# **Applicant's Response to Stop Lime Down Written Representations – Appendix D Transport Report**

**June 2026**

**Planning Inspectorate Reference: EN010168**

**Document Reference: EXAM/9.34**

Title: Figure 3-3: 400kV Substation and BESS Layout

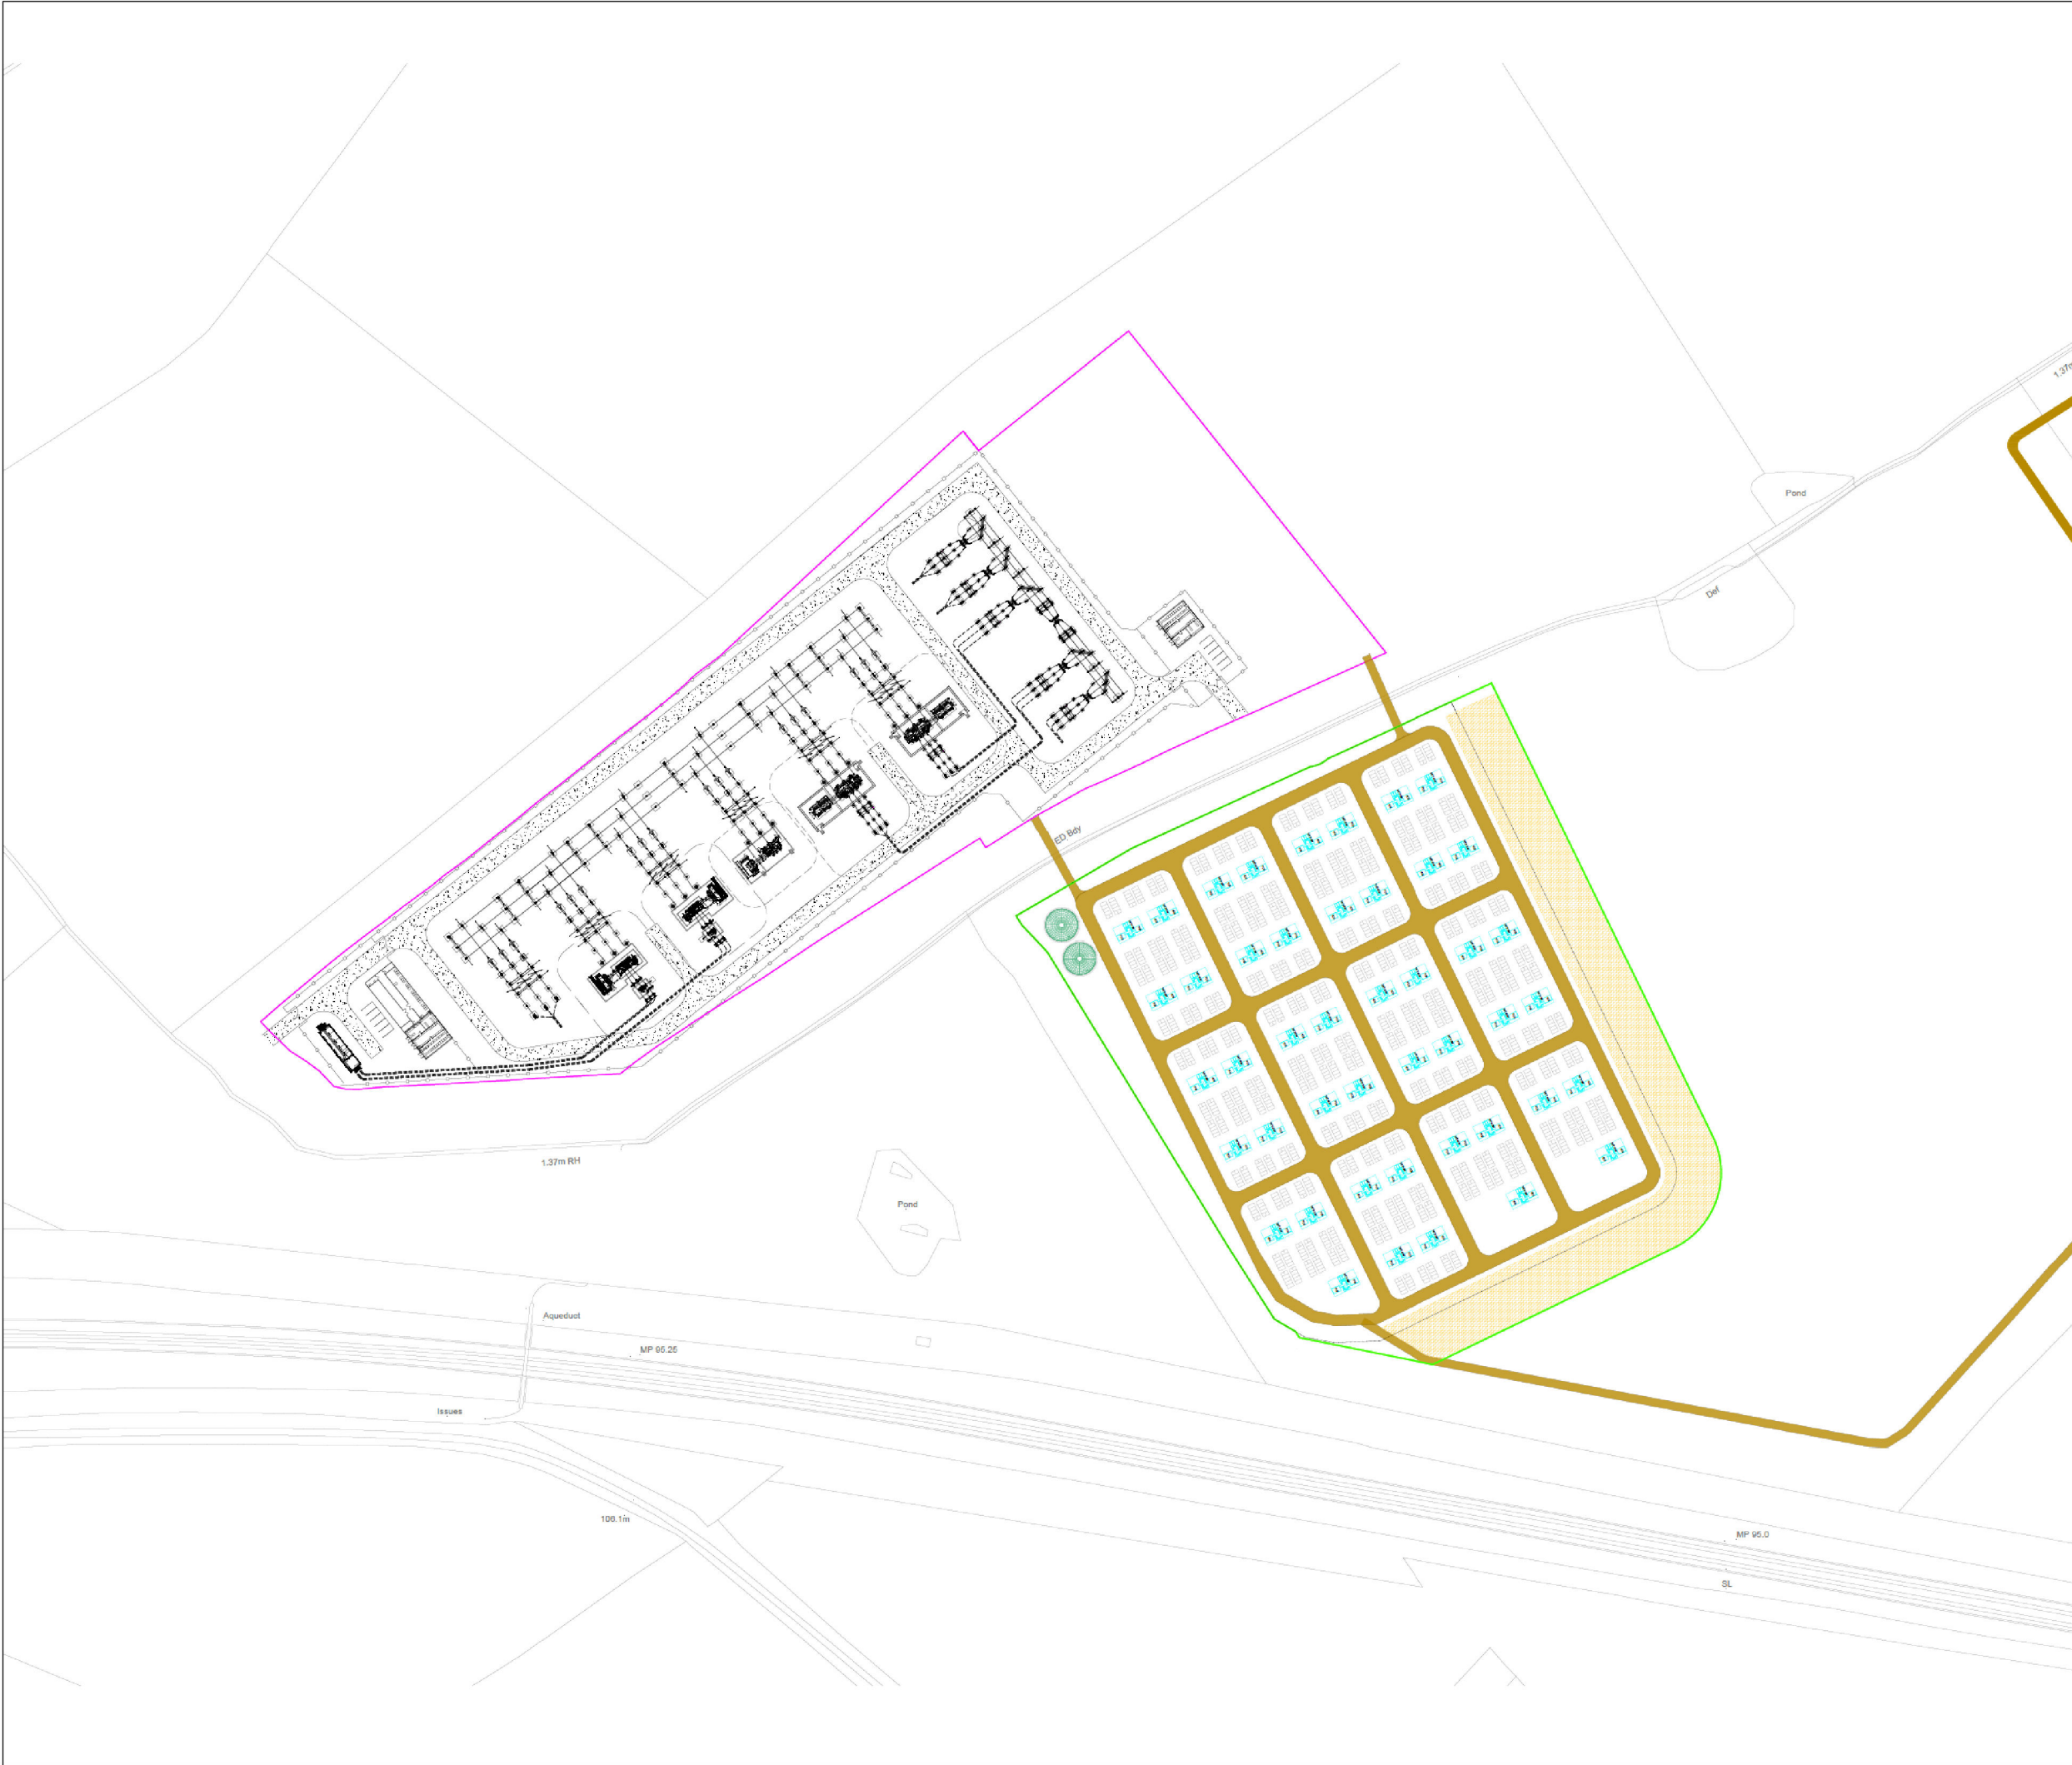
*“The calculation assume that the depth of foundations for the substations and BESS would be 0.3m. This is likely to be an underestimate, given the need for stable structures and the mass of the components involved;”*
- 2.1.14 The depth of the BESS Area in the Applicant’s assessment is assumed as 0.3 m minimum, and assumes the whole area is laid at this depth, when in reality much of the area that is not required for hardstanding will be permeable surface such as a reinforced grass system. The application of a uniform depth enables a realistic worst-case assessment, and allows for areas of deeper foundations offset with areas of permeable surfacing. The layout of the BESS Area is subject to detailed design.
- 2.1.15 Paragraph 2.9 bullet point 7 states:
